An
Bord
Pleanála

Inspector's Report

ABP-317874-23

Extraction of sand and gravel from quarry. An Environmental Impact Assessment Report (EIAR) and a Natura Impact Statement (NIS) have been submitted.

DRAWING TITLE:
Updated Phased Restoration Plan
DRAWING STATUS:
Planning

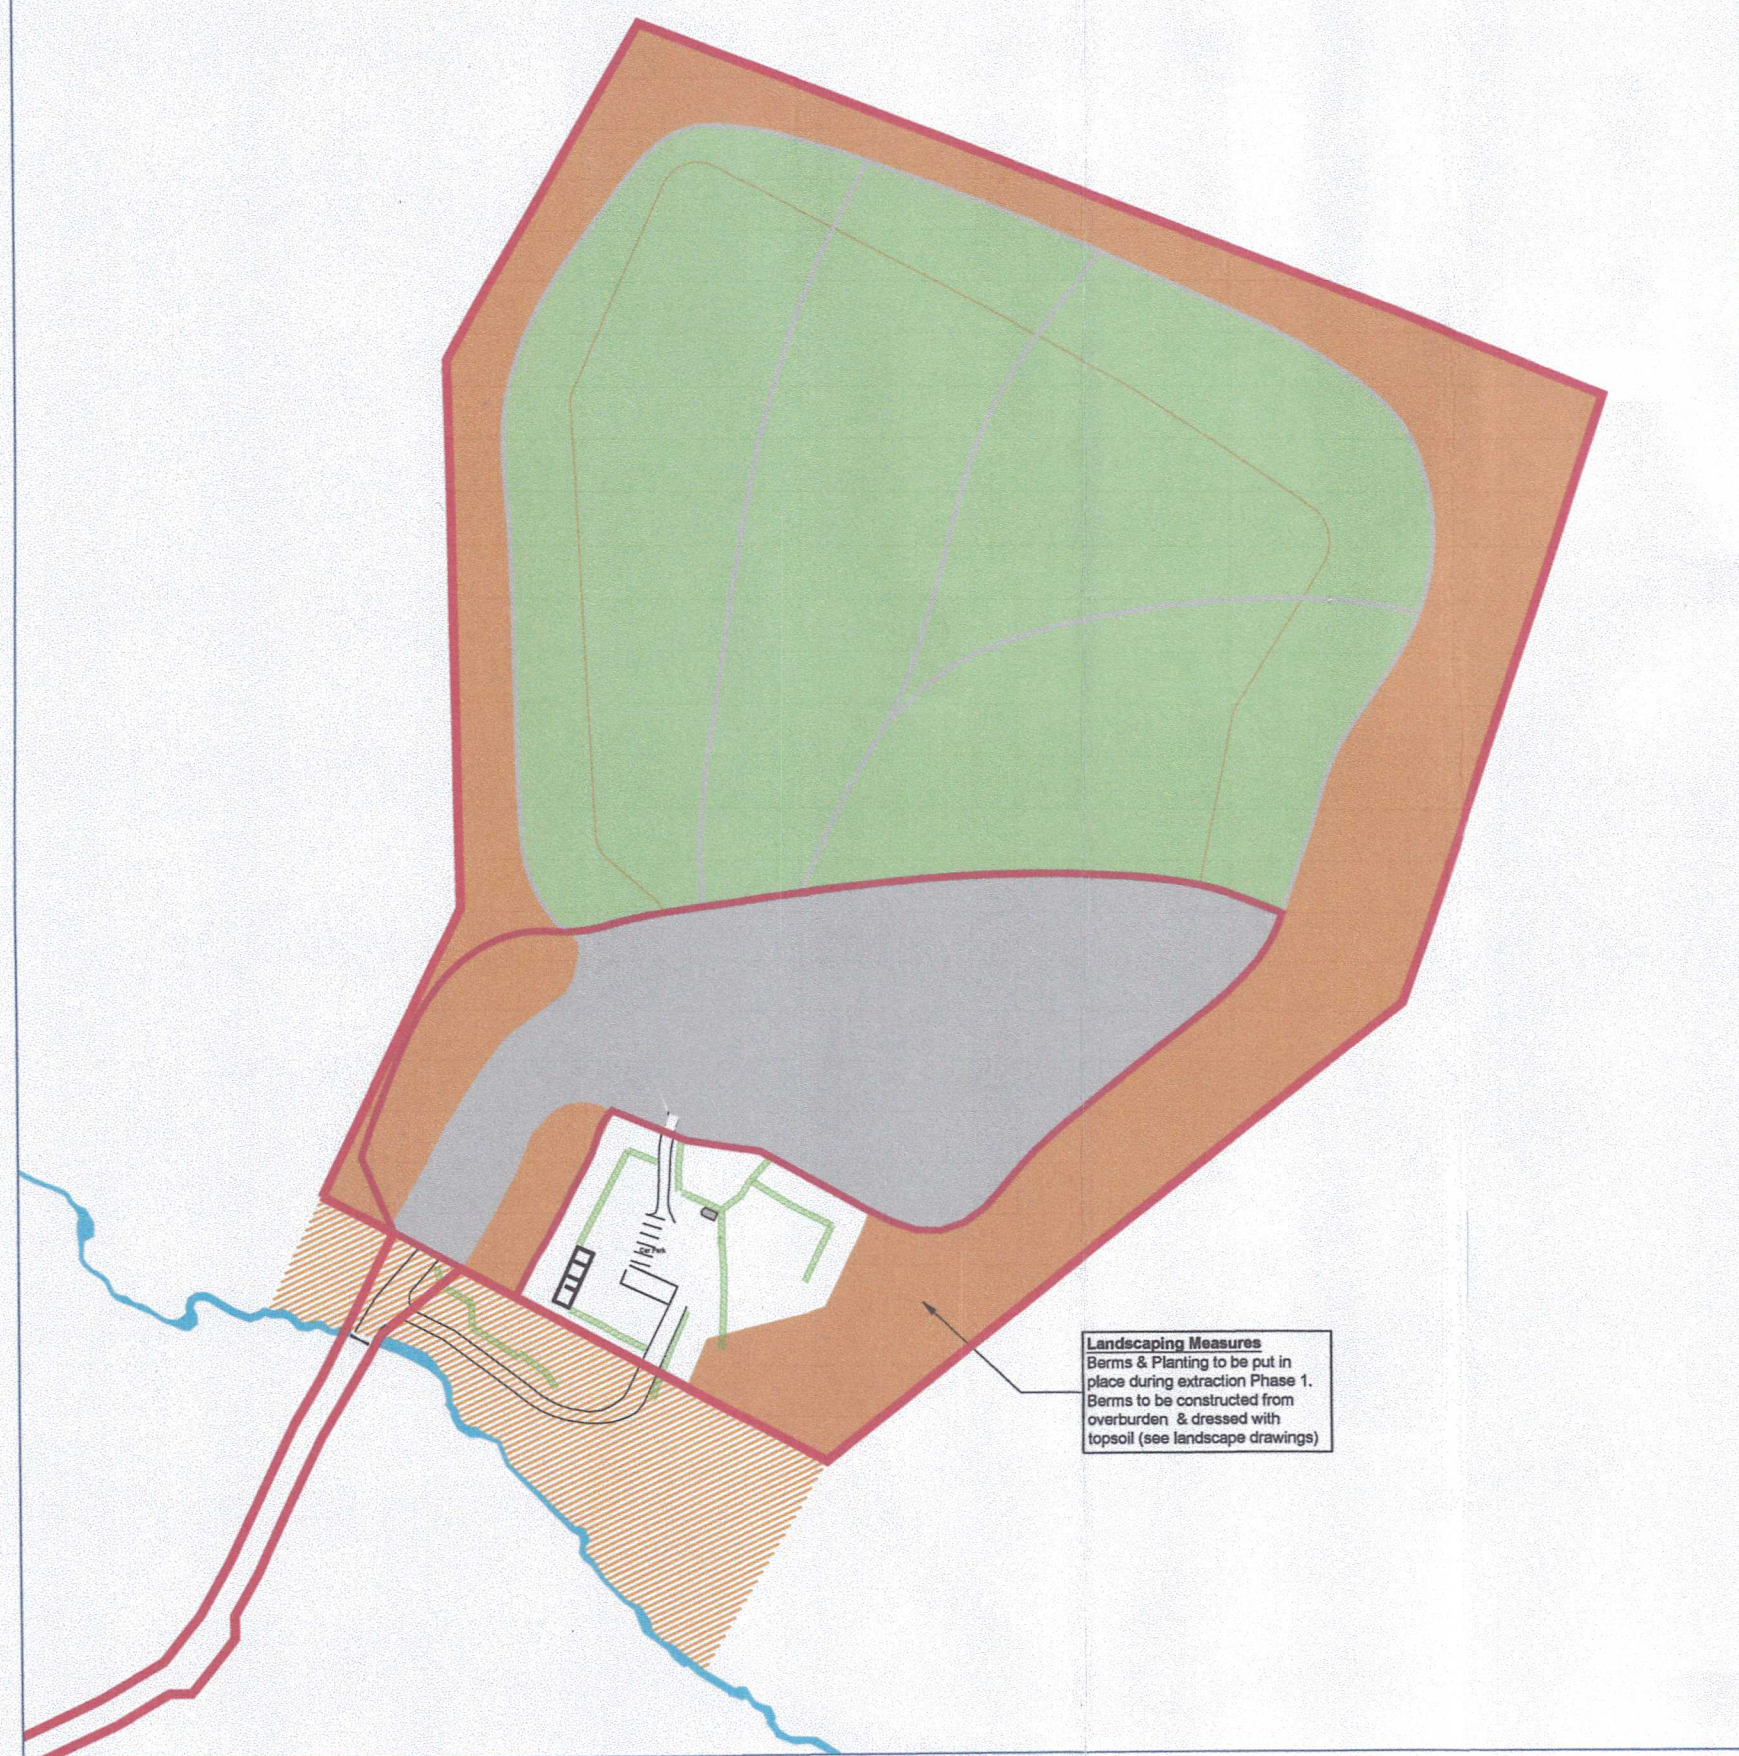
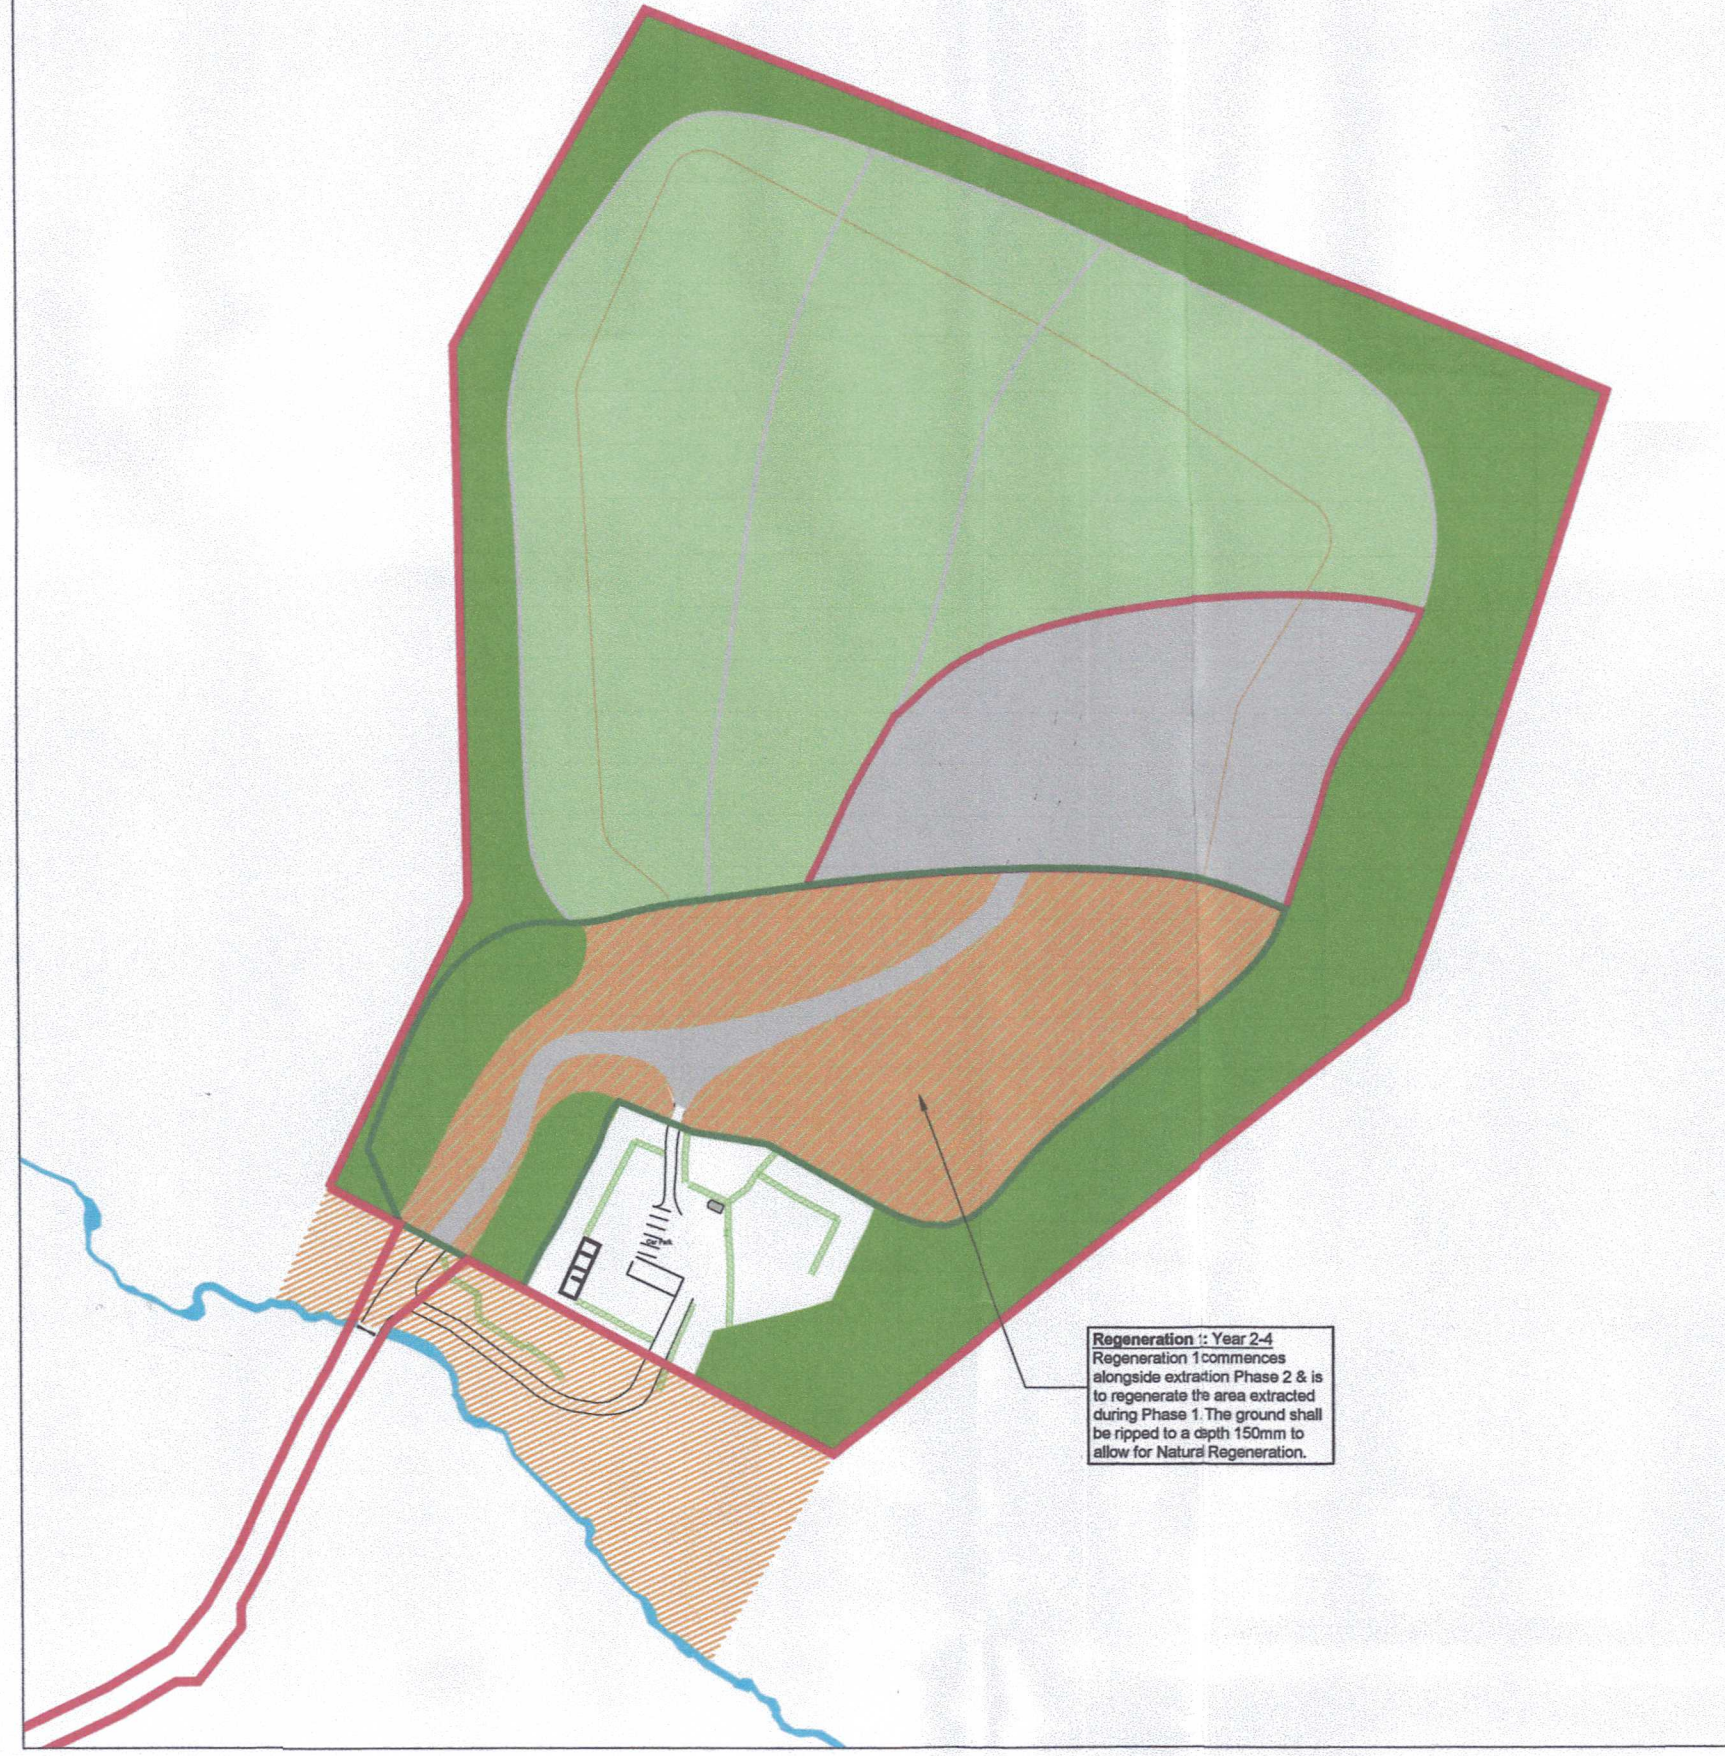
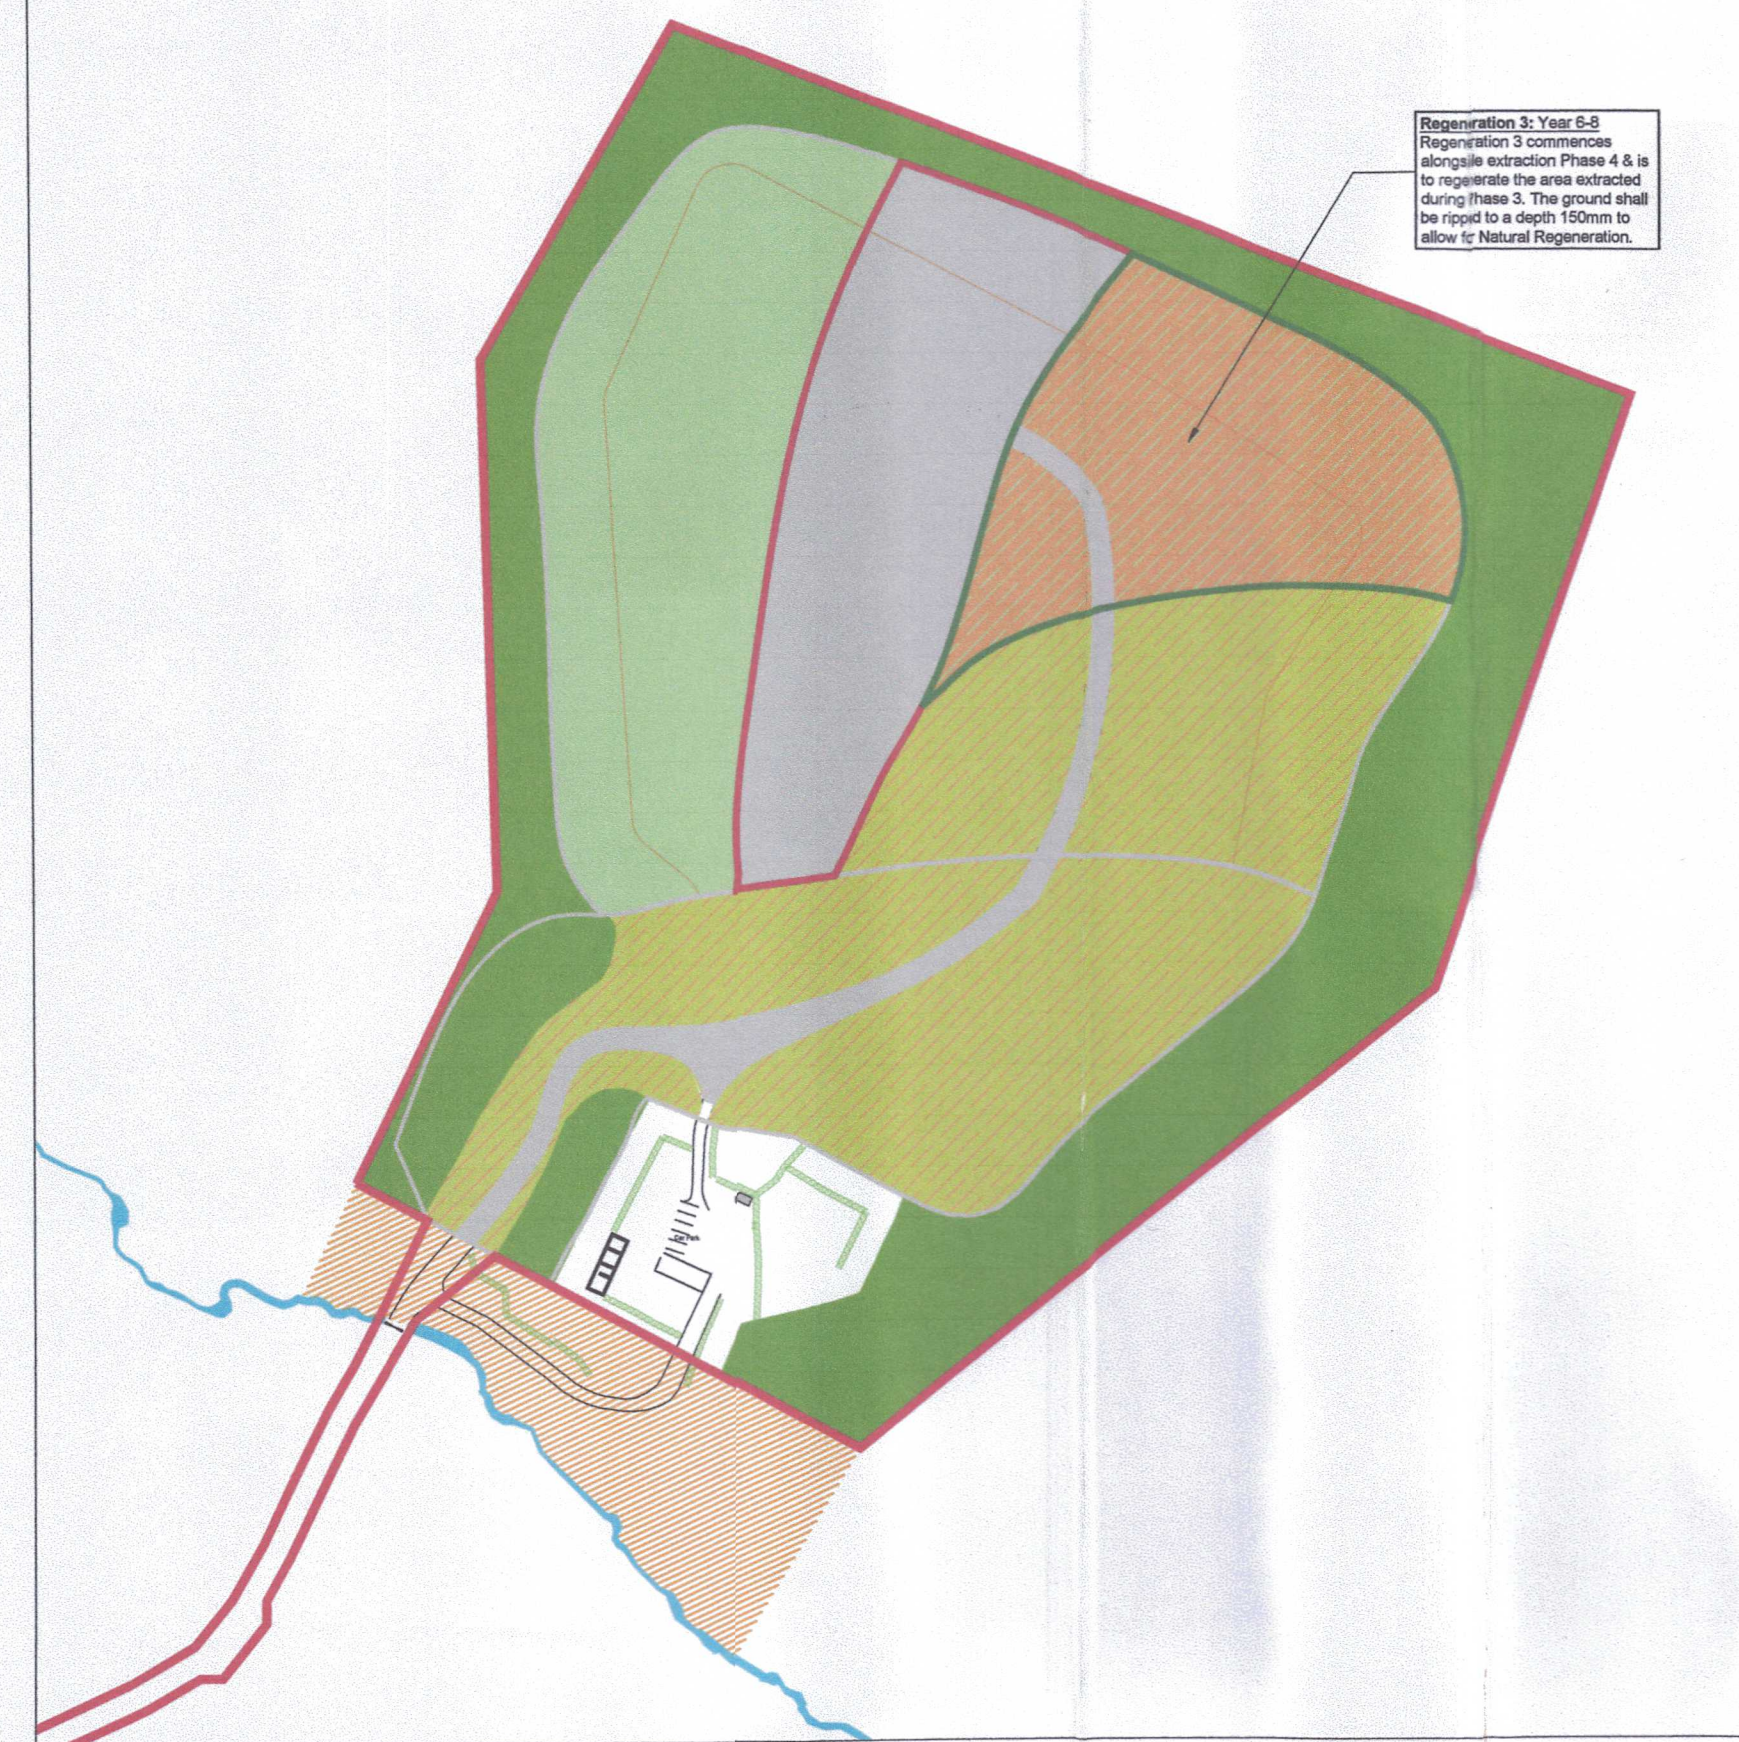
3.2.1.4. Within their response document (Part 1), the Applicant noted that there had been a change in the project description, and it was now proposed that restoration activities will be phased and happen concurrently with the phasing of extraction activities. A sequencing of the restoration phase compared to the extraction phasing is set out in Table 2-1 of their response document and they referred to the Updated Restoration Plan that accompanied their response. In addition to the supplementary assessments
